From:
To: [DCAdmin](#)
Subject: Application 2023/91939
Date: 12 August 2023 17:32:09

I am writing in response to your letter dated 14th July 2023 with regards to a proposed erection of two storey side and single storey rear extensions at 11 Burniston Drive, Oakes, Huddersfield, HD3 3 PR.

Drg No:
BD03.#

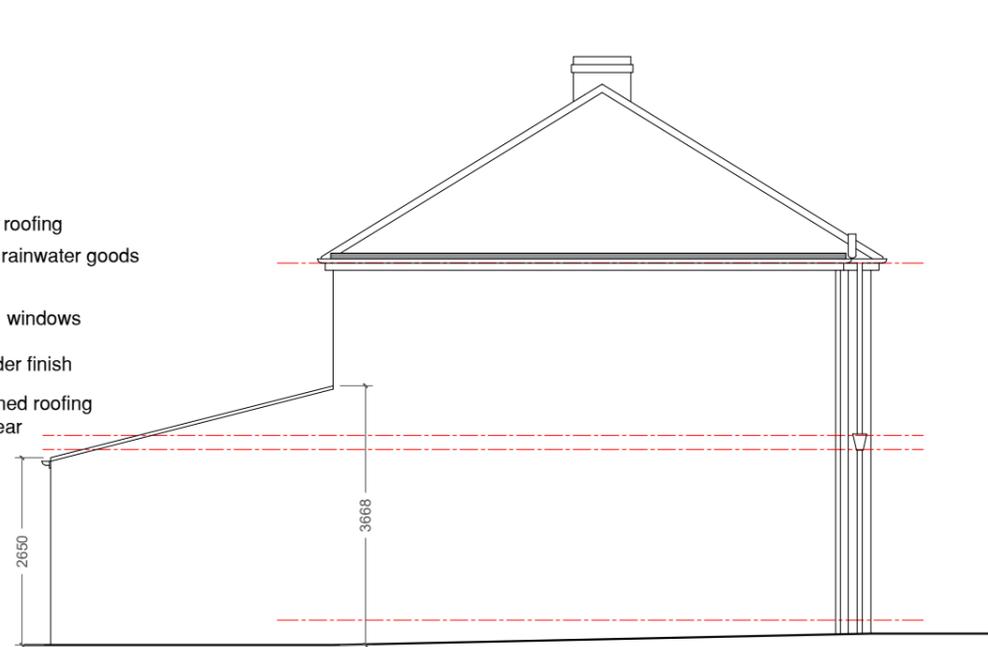
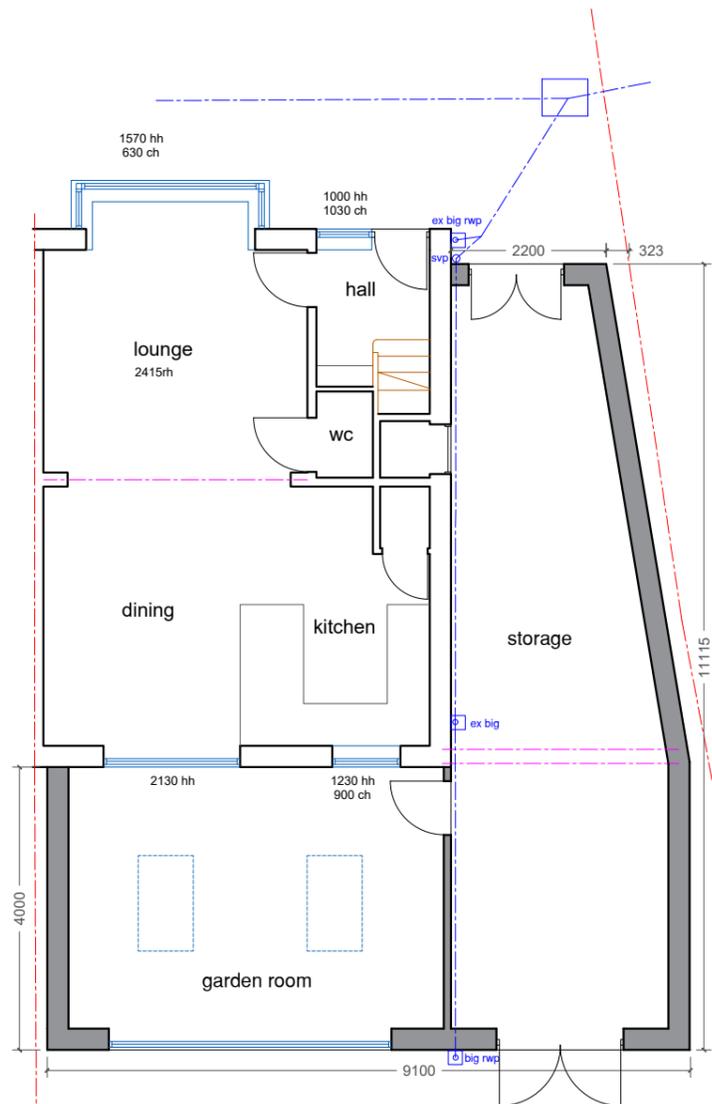
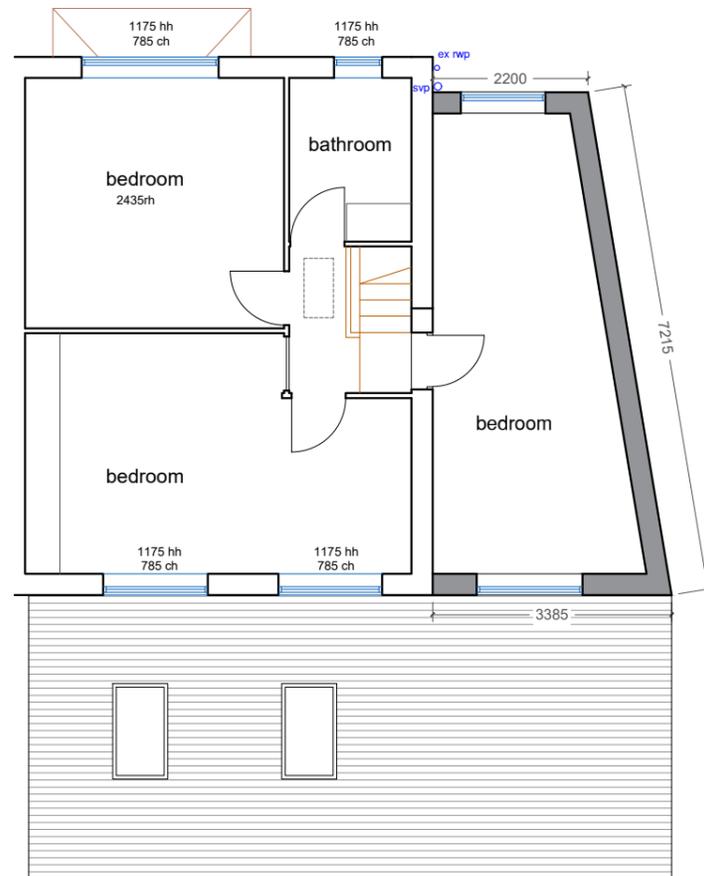
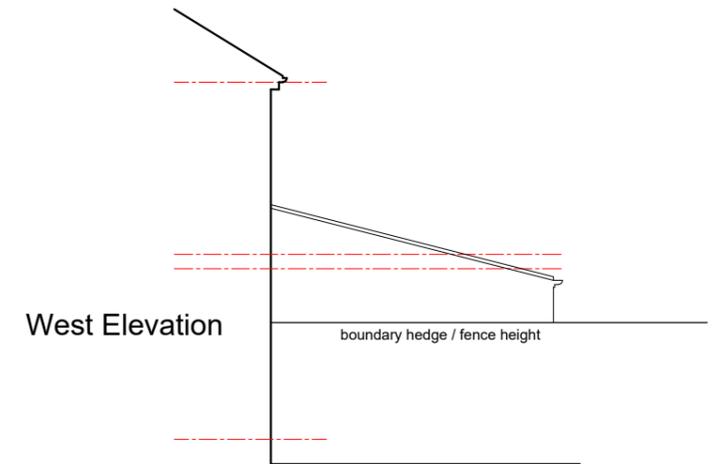
- Impact to adjoining property drive with surface water without a retaining wall or garden area, currently the drive at No11 is higher and previously there was a low stone wall (2 layers) that ensured no water ran into the adjacent drive and the garden also soaked the rainwater. Will the low wall be retained to ensure protection for the adjacent drive and what are the plans for the surface water run?

- Impact to adjoining property natural sunlight due to the two storey side extension. Currently we enjoy natural sunlight into the bathroom, hall and kitchen in the afternoon and this helps with reducing utility bills and optimises heat and light gain, what impact will the two storey side extension have as the plans will reduce or block this natural sunlight. I have reviewed this with the movement of the sun to understand the impact.

- Side elevation and side boundary space, is this adequate to ensure no impact of down pipes/rainwater gutters leakages onto neighbouring property. Space is only 325mm. Where will the main downpipes be situated given boundary space is below threshold.

- Any change or impact to current rear hedges or fencing for the side elevation and rear extension which borders No9?
